Application No: BE/85/20/HH
Site Address: 95 Sunningdale Gardens North Bersted Bognor Regis PO22 9LE
Description of works: 2 storey side extension and single storey rear extension

Thank you for your internet representation made on 3rd September 2020 which has been recorded as an objection with the comments as follows:

Proposed Elevations, Plans and Section

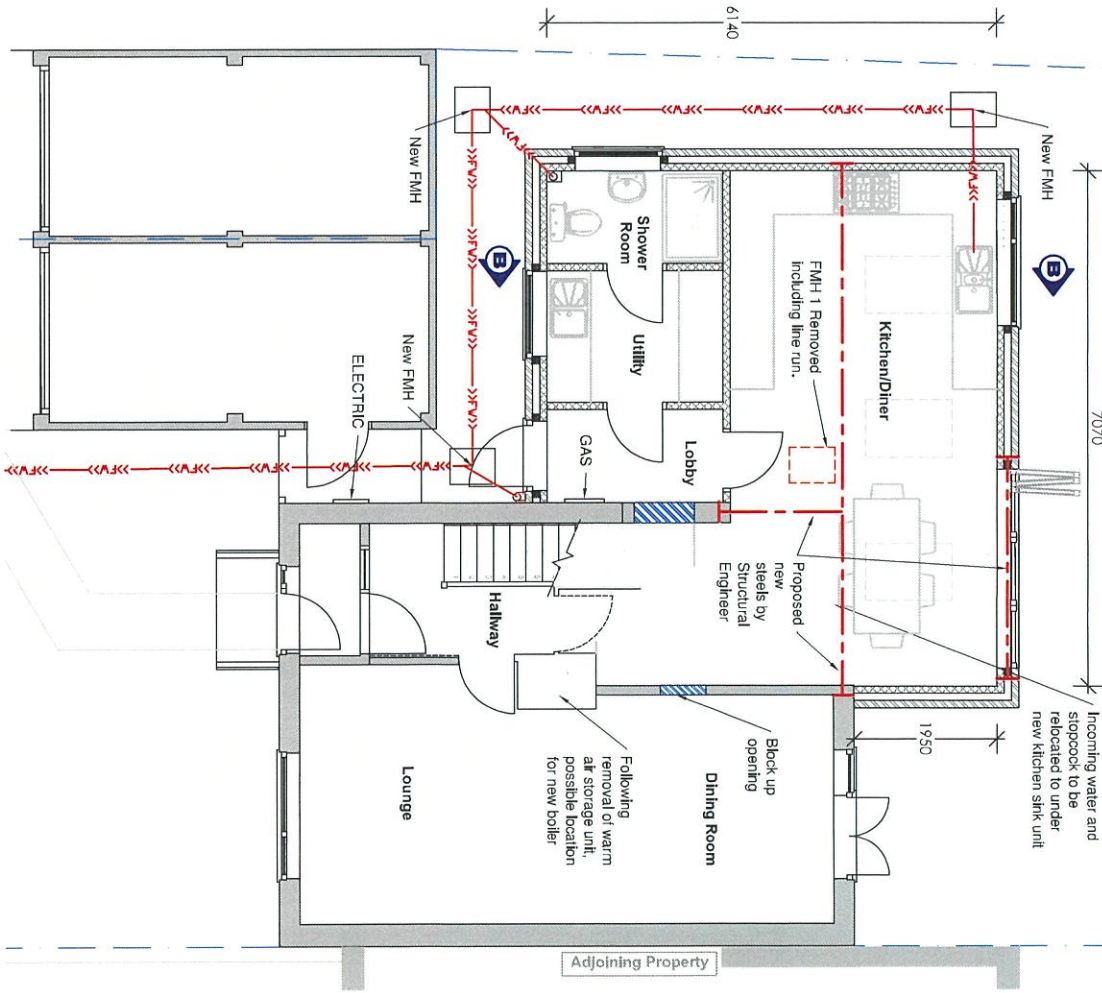
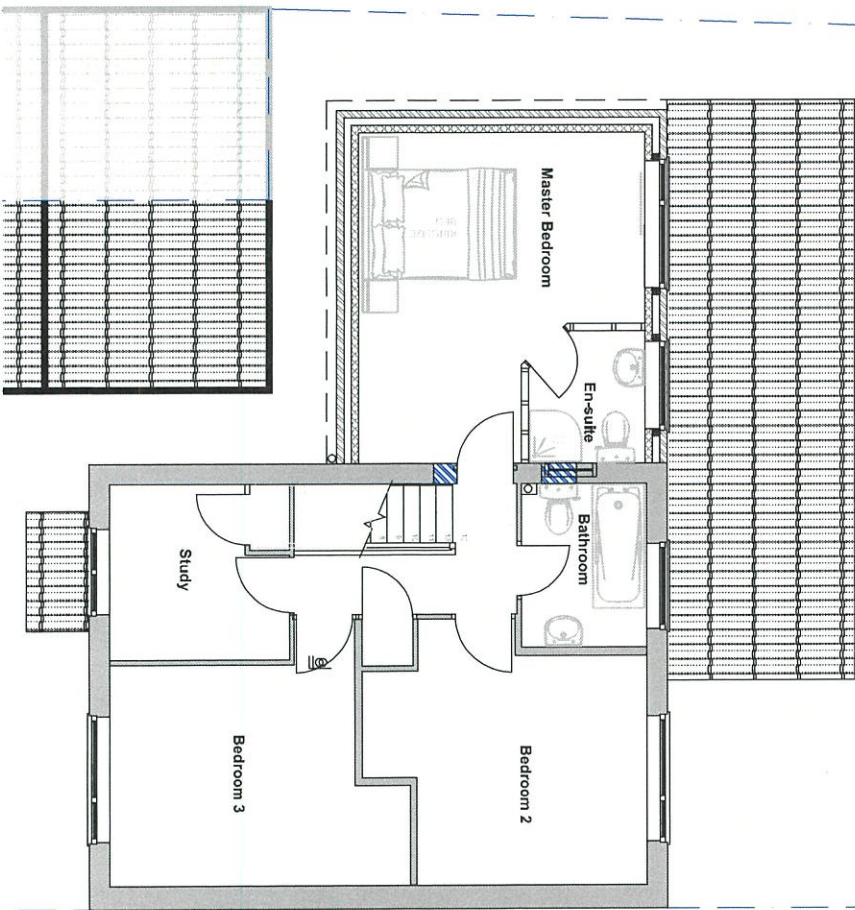
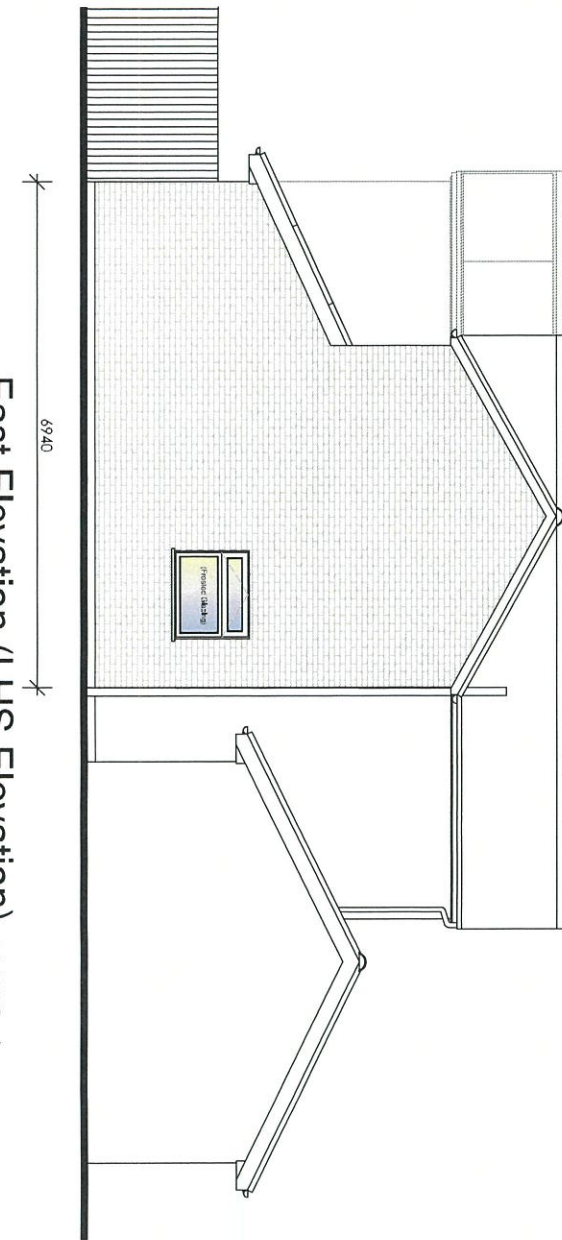
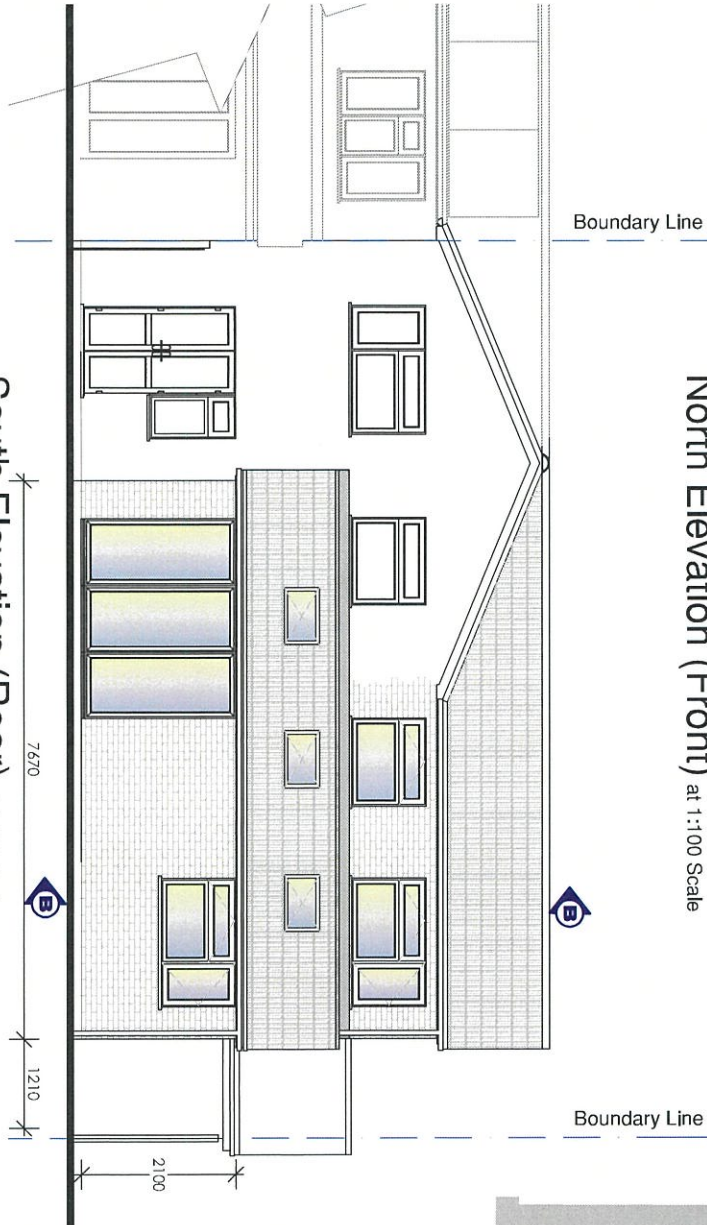
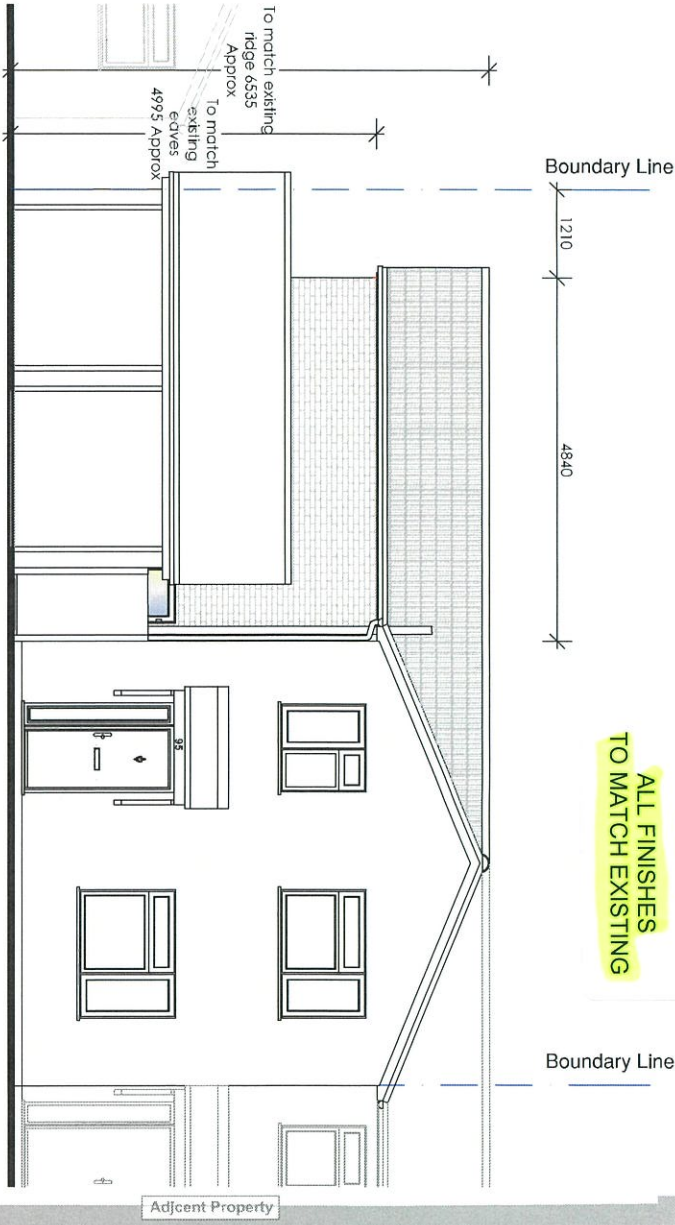
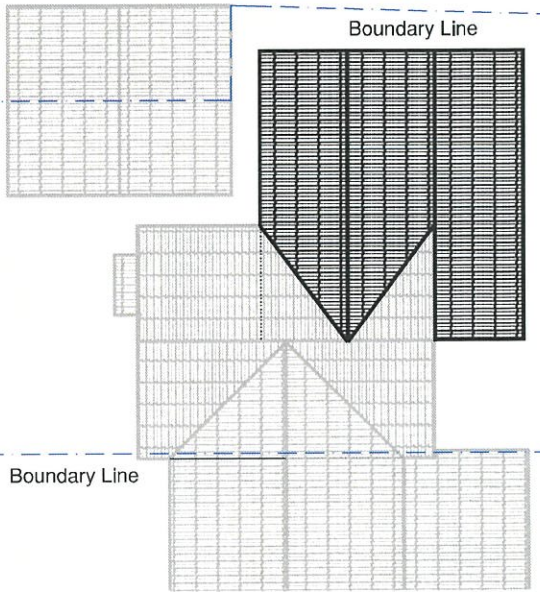
Object for the following: - the extension appears to be an overdevelopment of the site and overbearing on its neighbour, contrary to Arun DC Local Plan Policy D DM4.
